Application no: **3/2023/0738**

Address: **1 Ferry Butts Garstang Road Chipping PR3 2QJ**

Proposal: **Demolition of existing garage and workshop and replace with two-storey extension of living accommodation and domestic garage.**

The Local Highway Authority have viewed the plans and highway related documents and have the following comments to make:

PROPOSED SITE PLAN

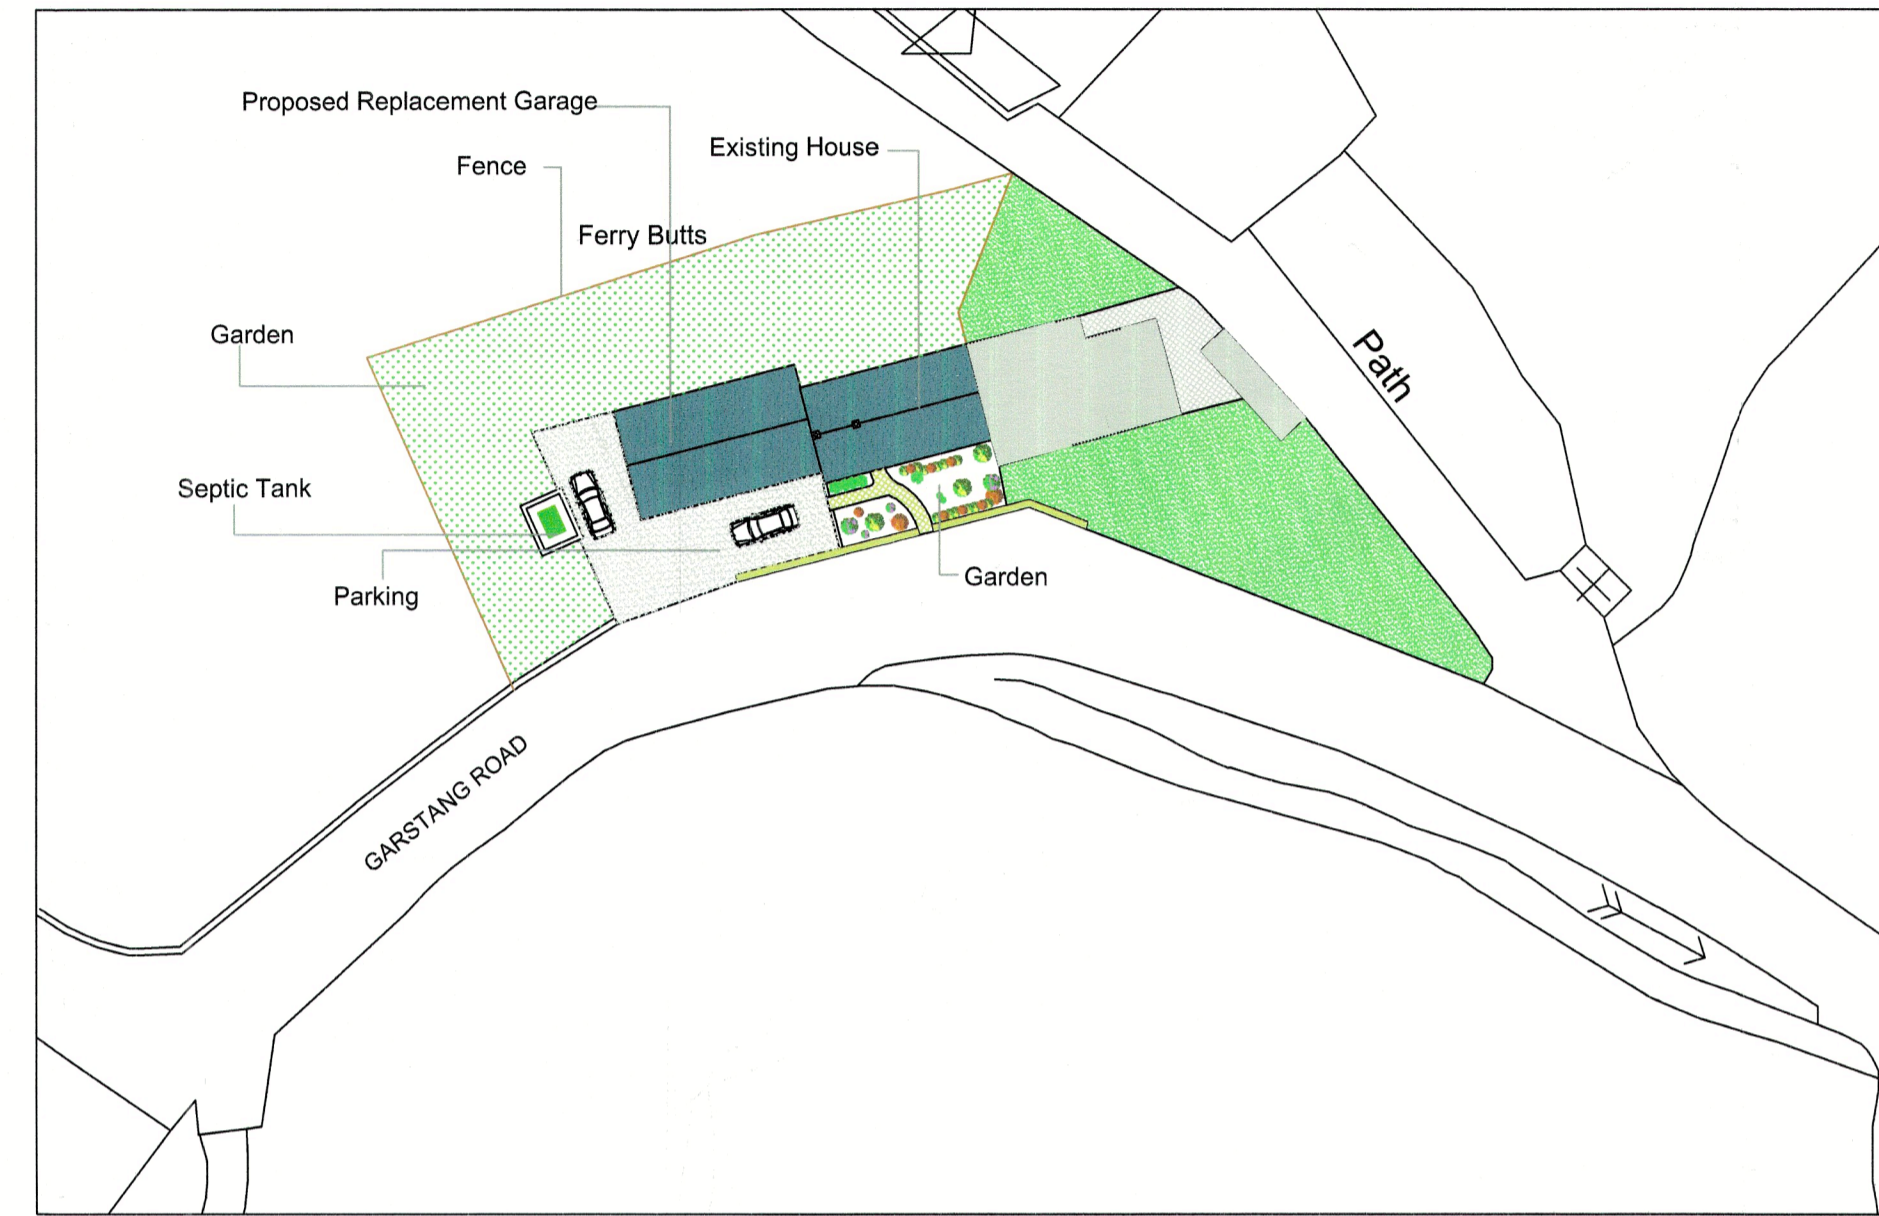
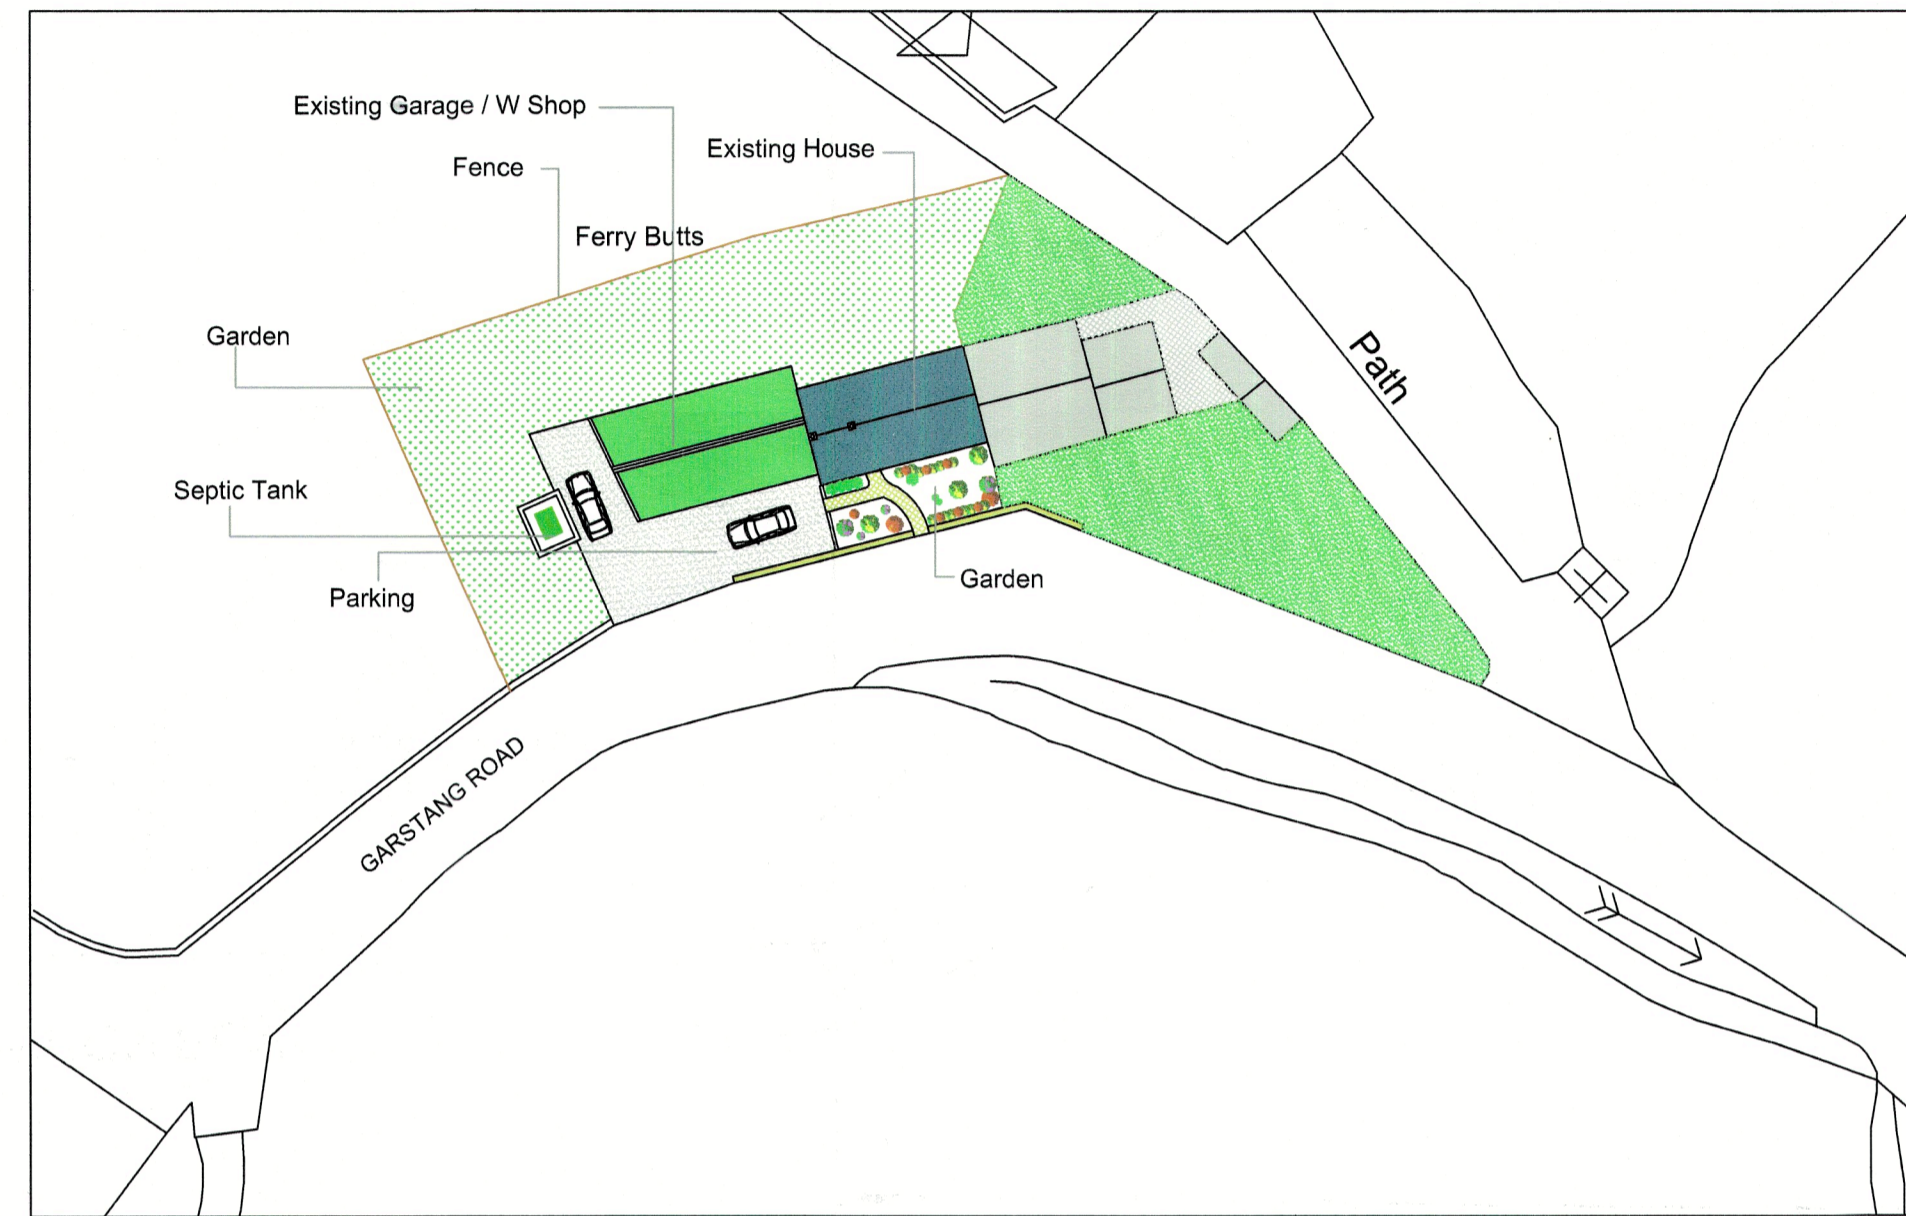
Despite this the LHA have reviewed J. Hadfield drawing number 545/203 titled "Existing, Proposed Site and Location Plans" and are aware that the site can provide a minimum of 3 car parking spaces and a turning area to enable vehicles to exit the site in a forward gear, on the existing hardstanding area adjacent to the proposed extension. Therefore, with the site complying with the LHAs parking guidance, the LHA have no objection to the proposal.

1. The development hereby permitted shall not be occupied until such time as the parking and turning facilities have been implemented in accordance with J. Hadfield drawing number 545/203. Thereafter the onsite parking provision shall be so maintained in perpetuity.

Ground Floor Plan.

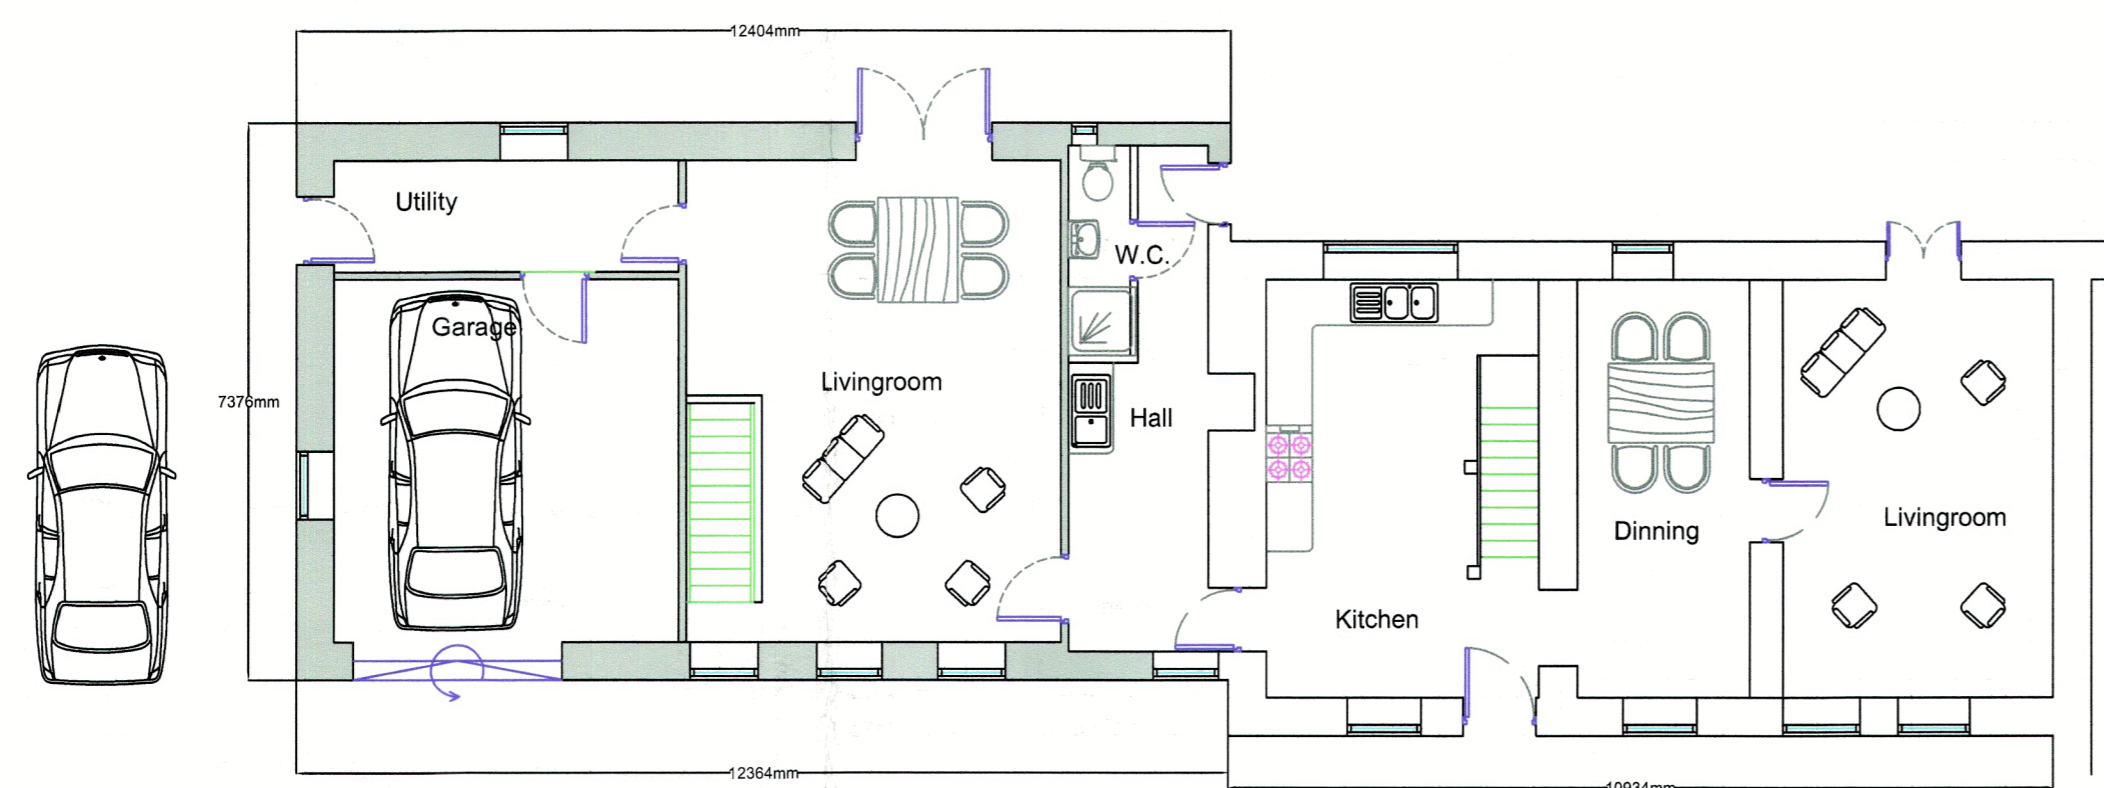
The LHA have reviewed J. Hadfield drawing number 545/202 titled "Proposed Plans and Elevations" and are aware that the number of bedrooms at the site will increase from 3 to 5. For the site to comply with the LHAs parking guidance as defined within the Joint Lancashire Structure Plan, the LHA require 3 car parking spaces to be provided on site.

As part of the parking arrangements, the Agent is proposing to provide a garage which will provide one car parking space. The LHA have reviewed the internal dimensions of the garage, as shown on the drawing, and are aware that the garage will be 5.3m long x 4.6m wide. Unfortunately, the garage does not comply with the LHAs guidance for a garage when providing a car parking space, with the LHA requiring the garage to be a minimum of 6m long.
